WEST SUSSEX COUNTY COUNCIL CONSULTATION

TO:	Arun District Council FAO: Mr S Davis
FROM:	WSCC - Highways Authority
DATE:	9 September 2019
LOCATION:	Rear of Inglenook Hotel 253-255 <u>Pagham</u> Road <u>Bognor Regis</u> <u>PO21 3QB</u>
SUBJECT:	<u>P/58/19/PL</u> Erection of 9 No. dwellings with associated access, parking, cycle & refuse storage & landscape design. This application is a Departure from the Development Plan & may affect the setting of a listed <u>building</u> . Additional information received.
DATE OF SITE VISIT:	09/09/2019
RECOMMENDATION:	No Objection
S106 CONTRIBUTION TOTAL:	n/a

2017-3763-002

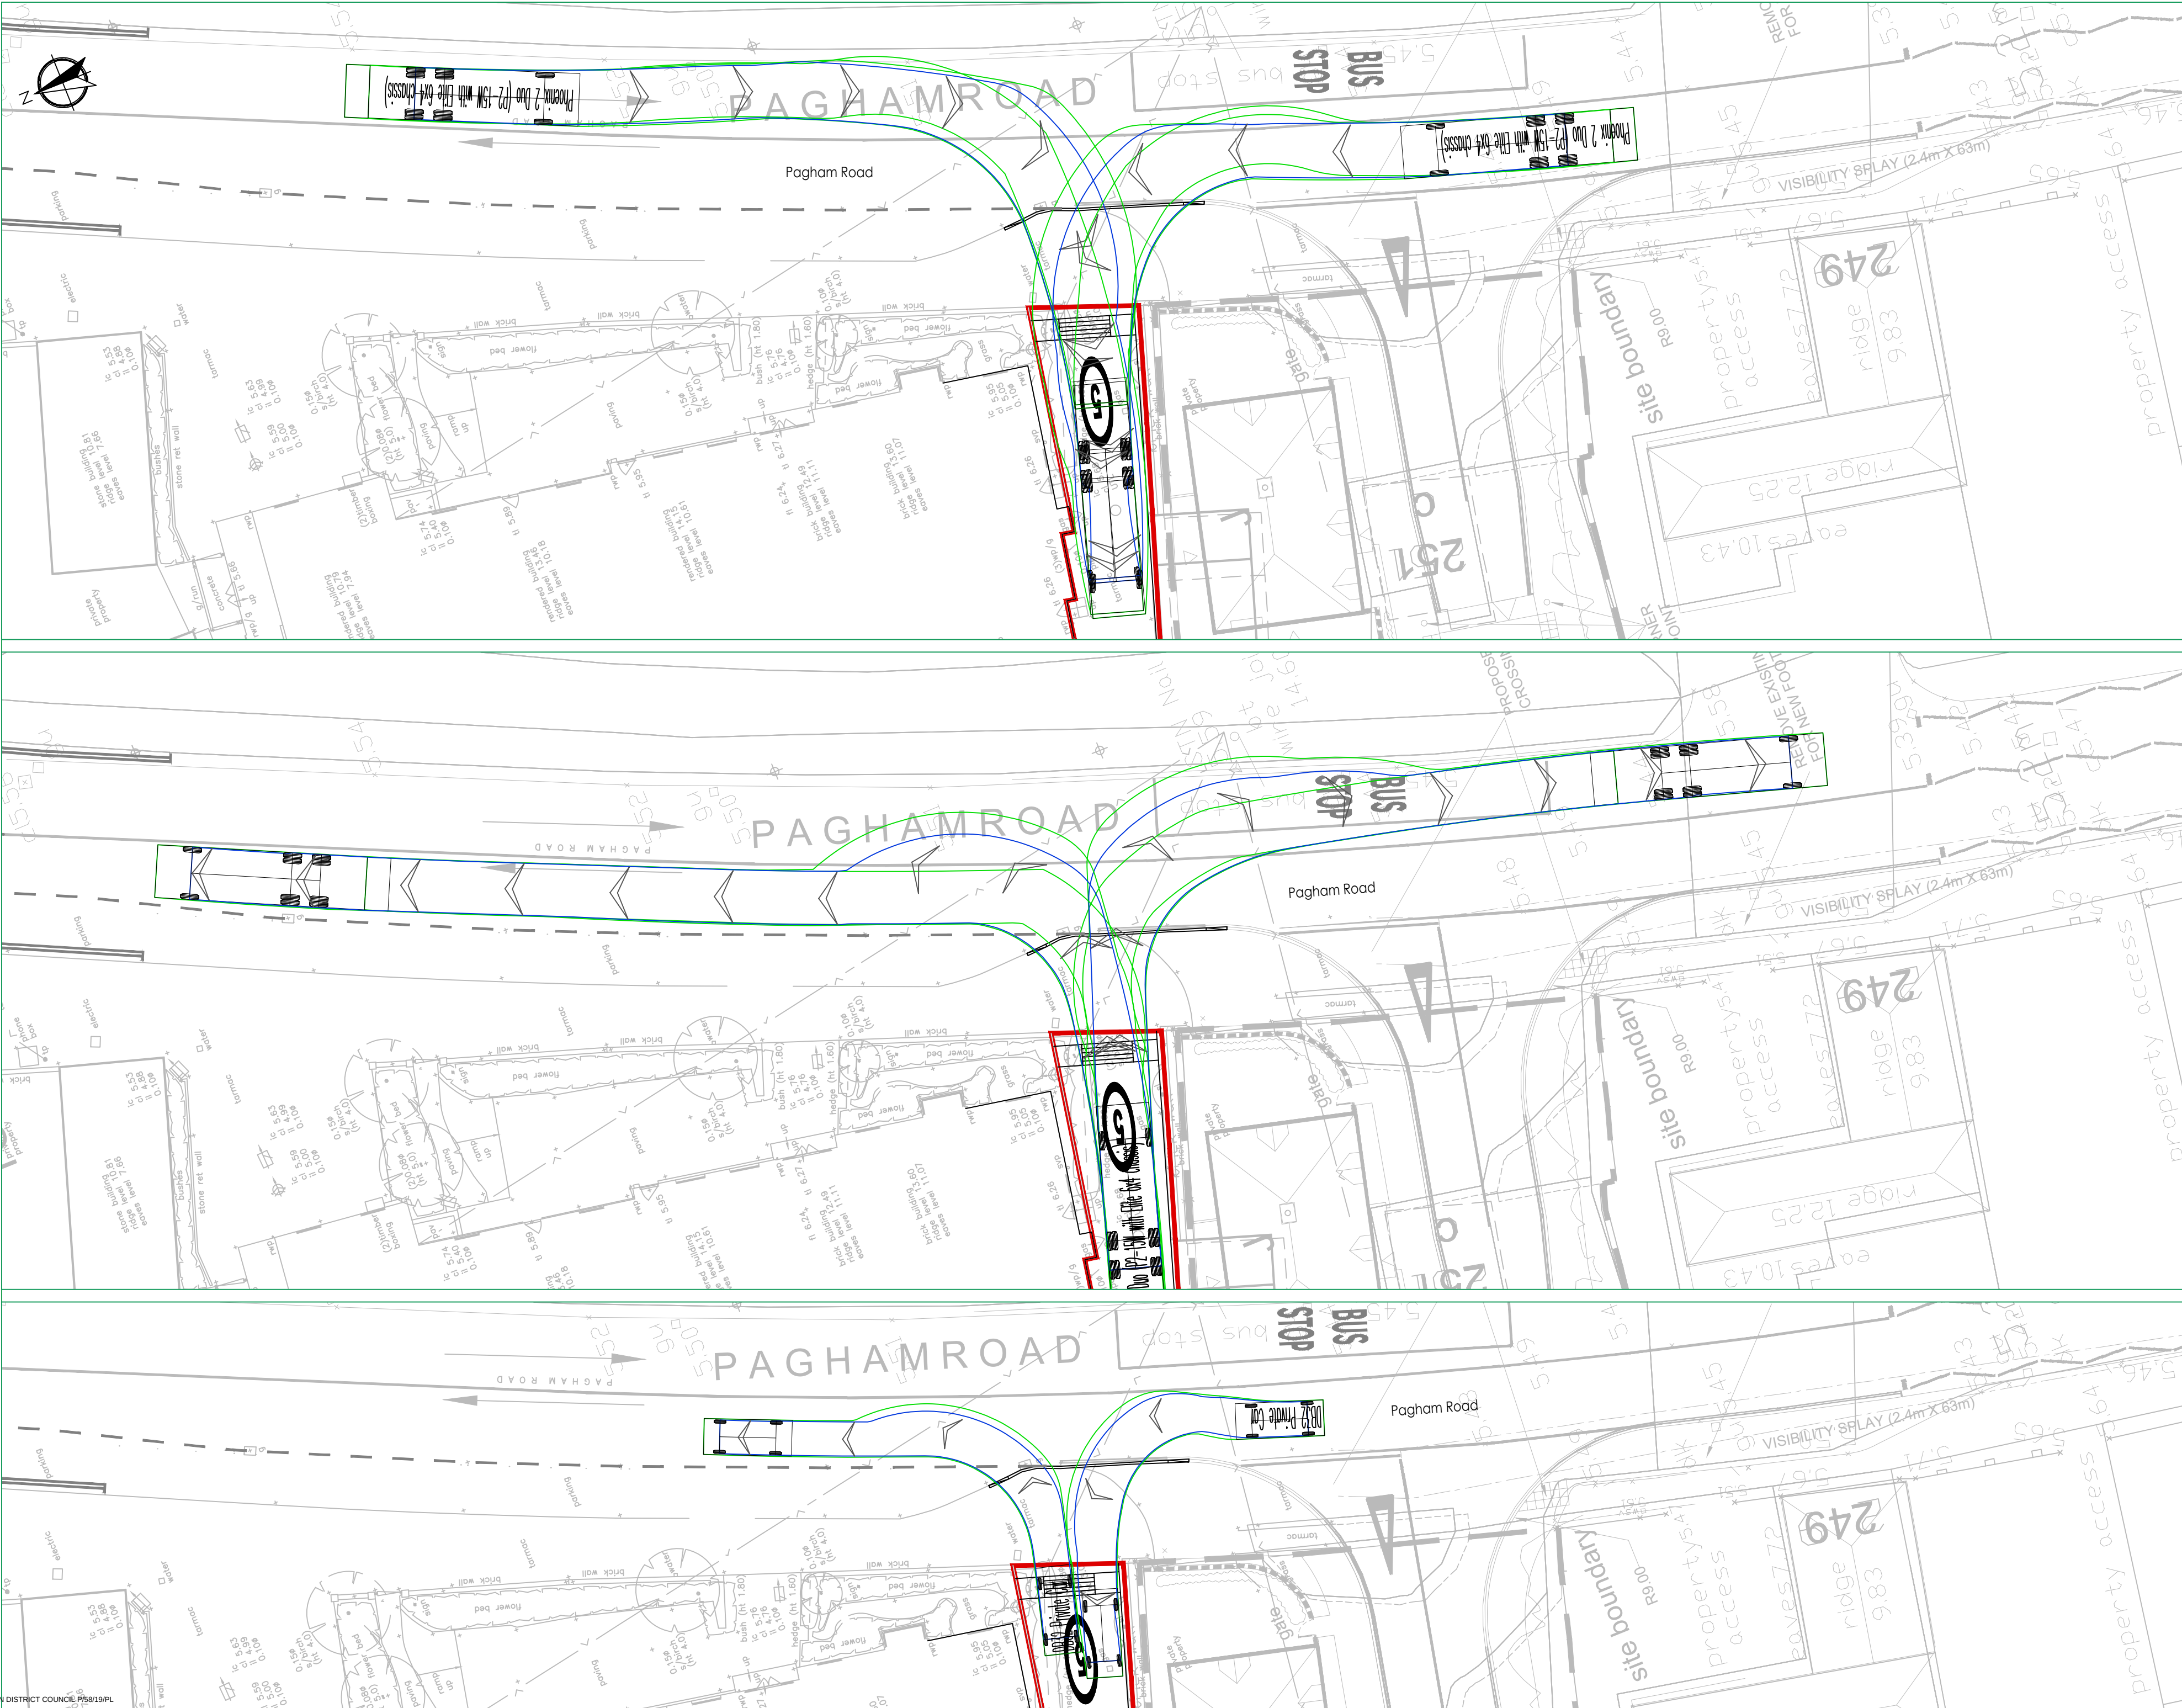
An ATC Speed Survey has been carried out at the site and records 85th percentile speeds of 30.4mph northbound and 27.7mph southbound. This equates to Stopping Sight Distance (SSD) requirements of 44m northbound and 39m southbound, these splays have been demonstrated within Drawing 2017/3763/002 and fall within the Highway Boundary and not the property boundary.
